**City of Portland, Maine - Building or Use Permit Application**  
 389 Congress Street, 04101 Tel: (207) 874-8703, Fax: (207) 874-8716

<b>Permit No:</b> 07-1335	<b>Issue Date:</b>	<b>CBL:</b> 116 B018001
------------------------------	--------------------	----------------------------

<b>Location of Construction:</b> 44 WILLIAM ST	<b>Owner Name:</b> CORNELL THERESA N M	<b>Owner Address:</b> 18 READ ST	<b>Phone:</b>
<b>Business Name:</b>	<b>Contractor Name:</b> Buchanan Remodeling	<b>Contractor Address:</b> P.O. Box 6771 Portland	<b>Phone</b> 2076323390
<b>Lessee/Buyer's Name</b>	<b>Phone:</b>	<b>Permit Type:</b> Alterations - Multi Family	<b>Zone:</b>

<b>Past Use:</b> Multi- Unit - 3 family	<b>Proposed Use:</b> Multi-unit - 3 family - Remove old deck, rebuild, replace roof under 2nd floor deck	<b>Permit Fee:</b> \$420.00	<b>Cost of Work:</b> \$40,000.00	<b>CEO District:</b> 2
<b>Proposed Project Description:</b> Remove old deck, rebuild, replace roof under 2nd floor deck		<b>FIRE DEPT:</b> <input type="checkbox"/> Approved <input type="checkbox"/> Denied	<b>INSPECTION:</b> Use Group: Type	
		Signature:	Signature:	
<b>PEDESTRIAN ACTIVITIES DISTRICT (P.A.D.)</b>				
Action <input

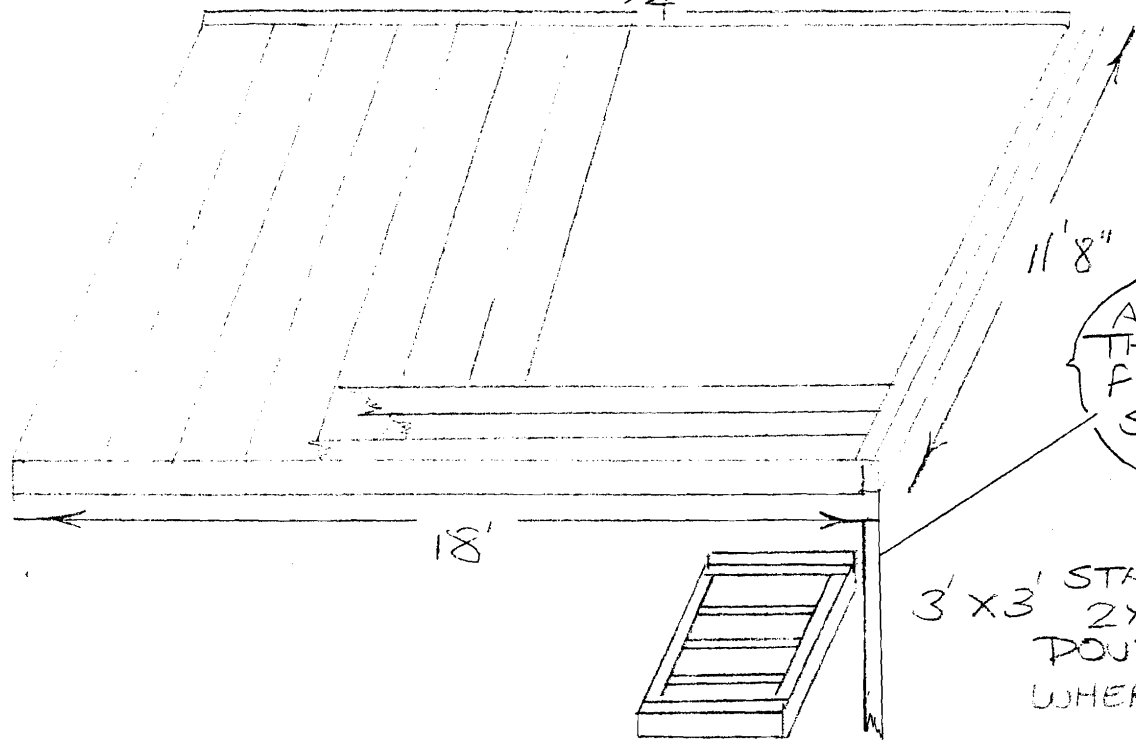
- 1) Frost protection must be installed per the enclosed detail as discussed w/owner/contractor.
- 2) As discussed during the review process, ballusters must be spaced with less than a 4" opening between each.
- 3) Open risers are permitted, provided that the opening between treads does not permit the passage of a 4" diameter sphere.
- 4) Your guardrail system installed around your deck must meet the loading requirements of section 1607.7.1 of the IBC 2003 Building Code.
- 5) Fastener schedule per the IRC 2003
- 6) Guards must be 42 inches in height with openings less than 4 inches. Graspable rails must be installed on both sides of the stair guard. Stair treads shall not be less than 11". Stair risers shall not be more than 7".
- 7) This permit DOES NOT certify the use of the property or building. It only authorizes the construction activities.
